## DECISION DELEGATED TO HEAD OF PLANNING

**Application No:** H08-0744-25      **Applicant:** Mr M Van Lier  
**Proposal:** Erection of 2 Detached Bungalows  
**Location:** Adj. 43 Mill Lane Gosberton Spalding  
**Terminal Date:** 15th December 2025

Floor Layout
1 : 100

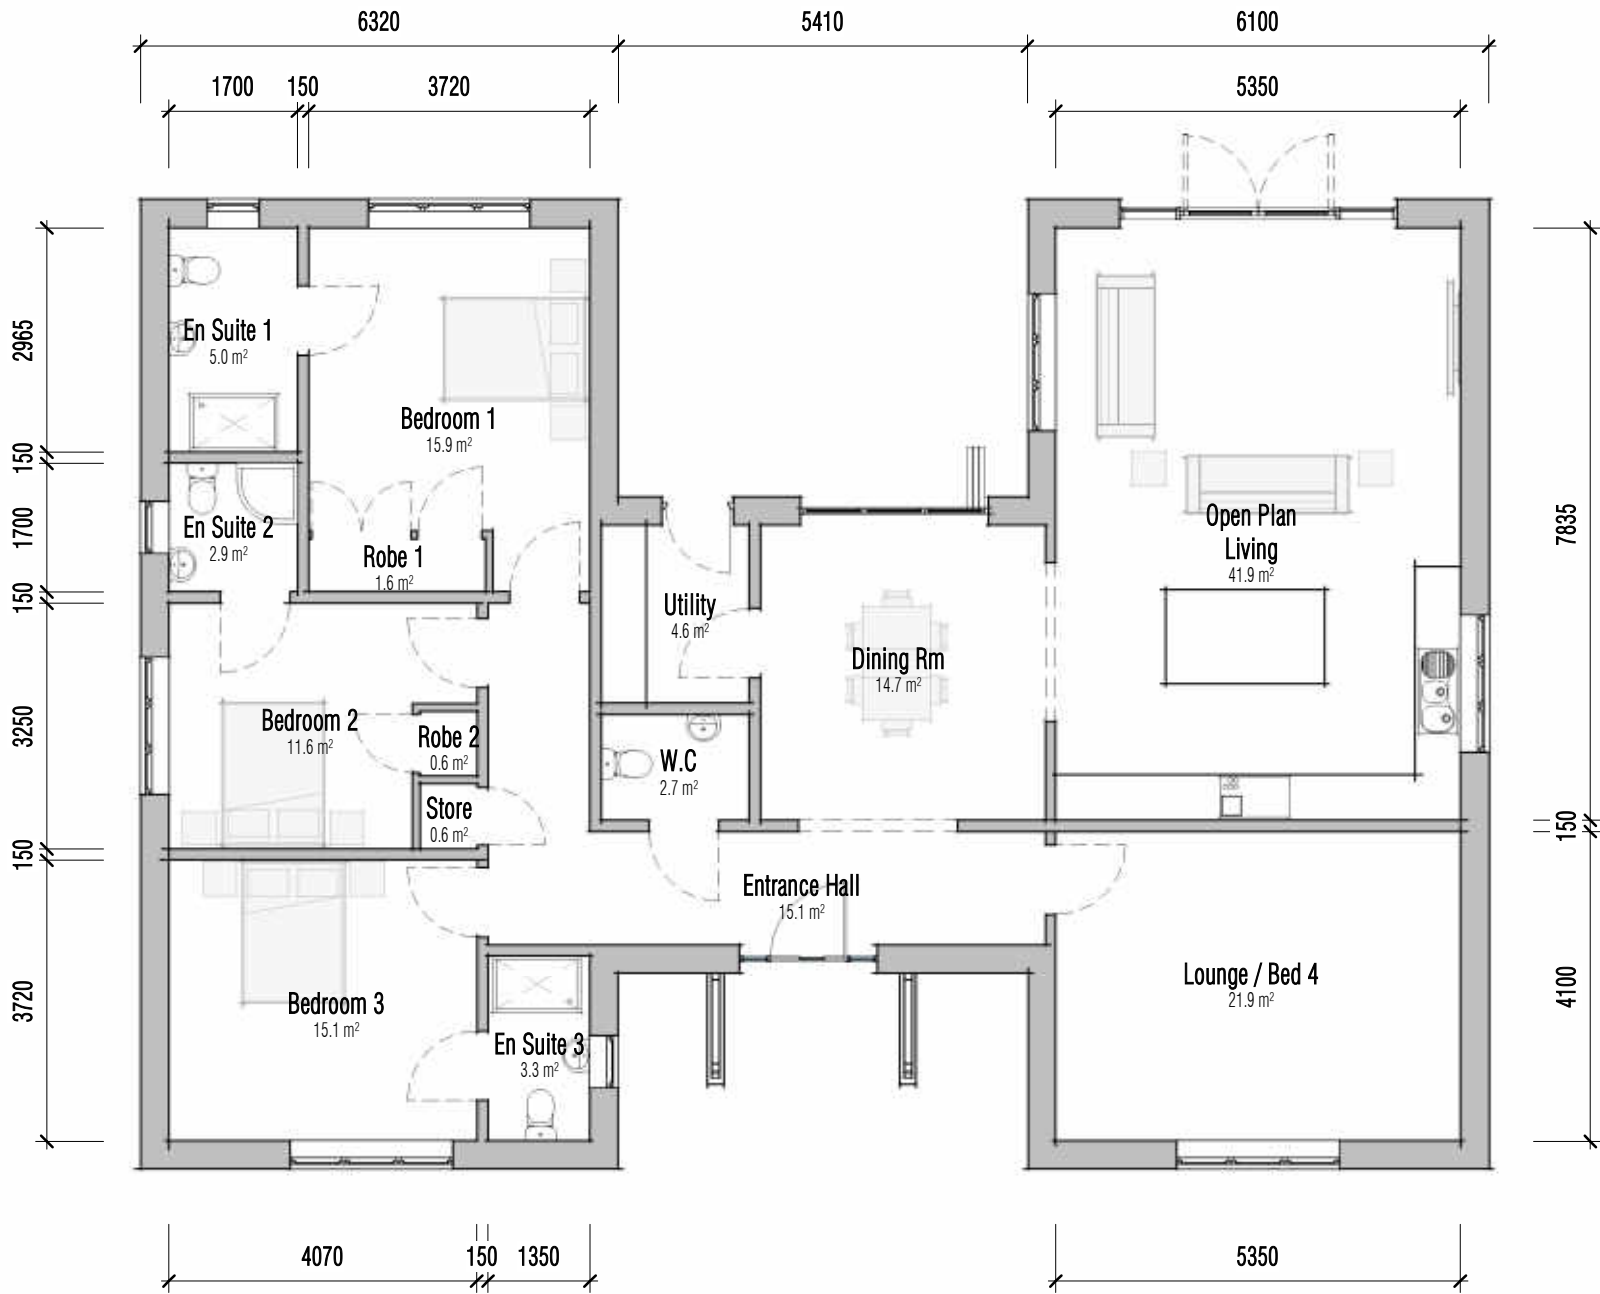
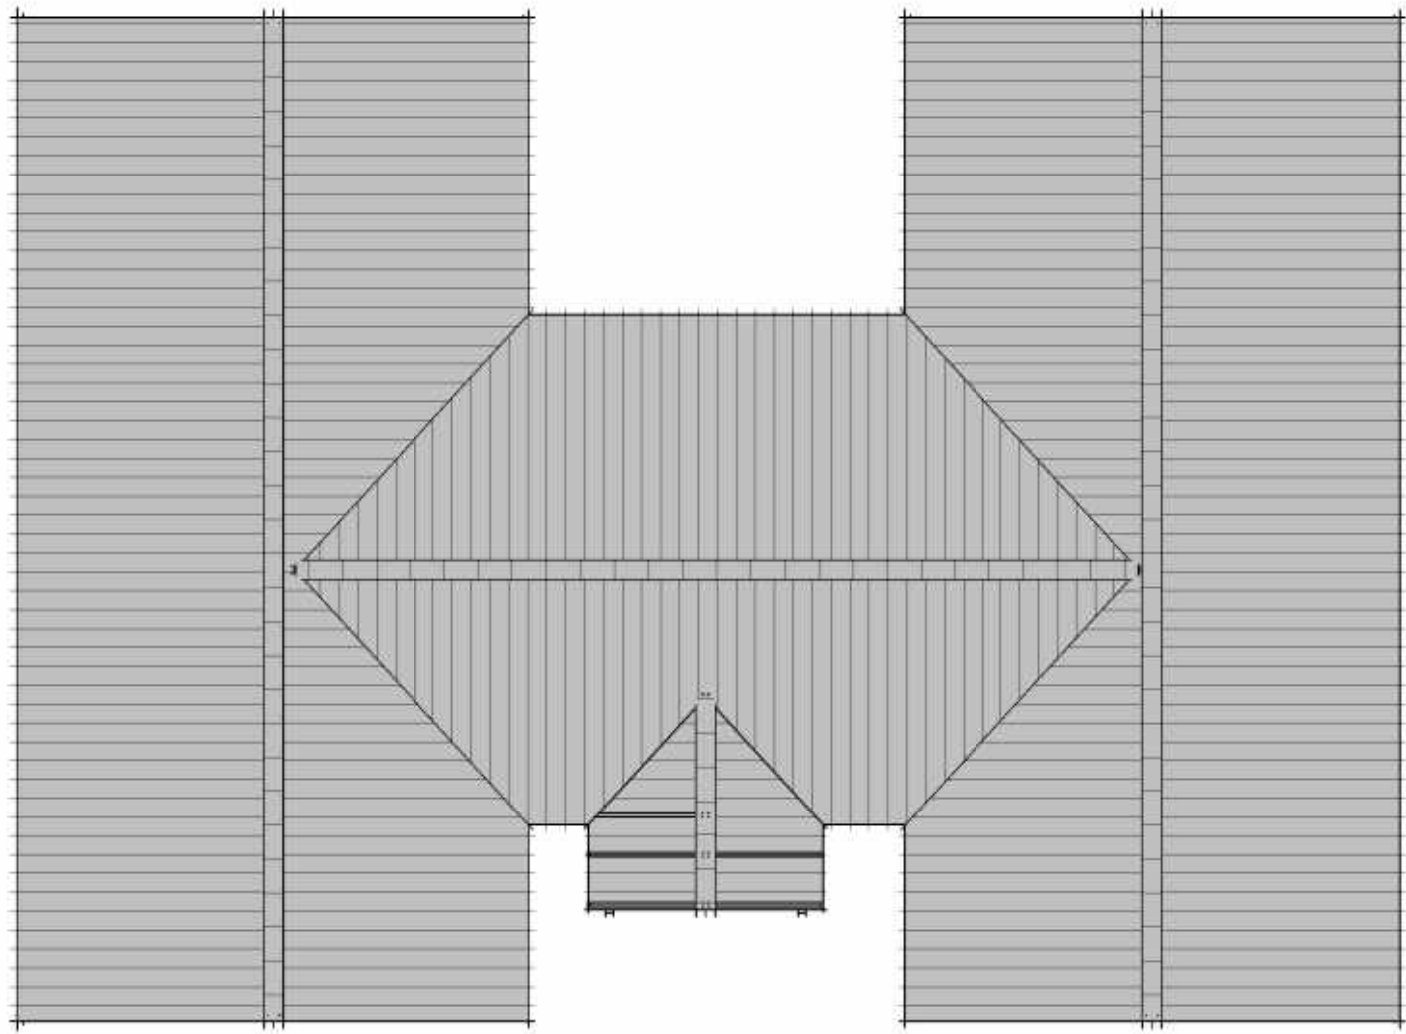
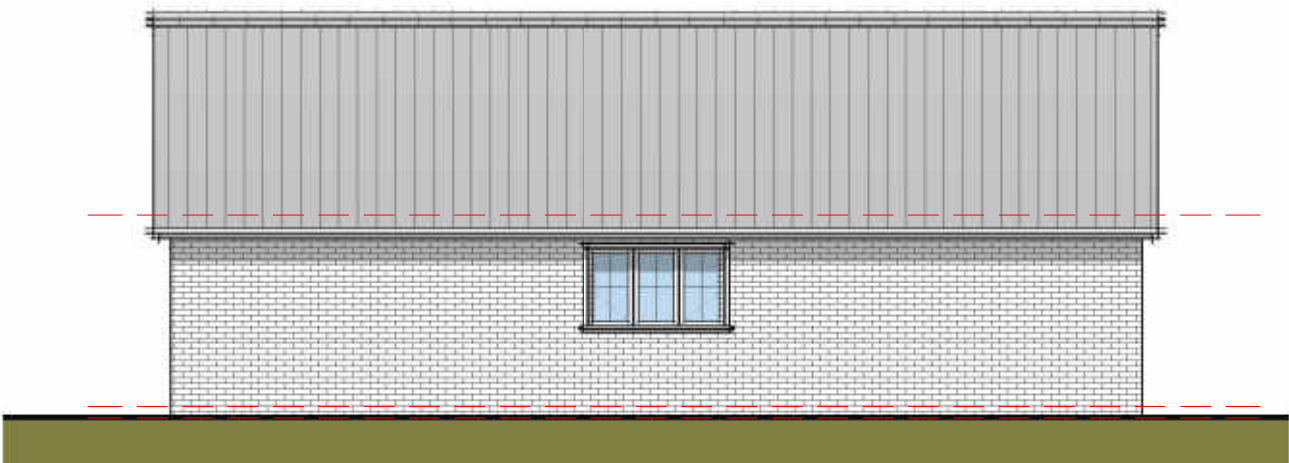
Given the design proposed, comprising a 'H-Shaped' arrangement, the overall scale of each dwelling, coupled with the somewhat awkward arrangement and siting of the easternmost plot, which is at odds with the more linear pattern of the neighbouring plots, the development appears cramped in nature and introduces a detrimental addition to the area.

Despite the varied designs in the area, the proposed designs are considered to be unacceptable in this setting, representing an incongruous form of development at odds with existing design preferences. The "H" arrangement fails to respect the existing built form of the area, whilst the resultant scale would exceed typical dwellings in the area.
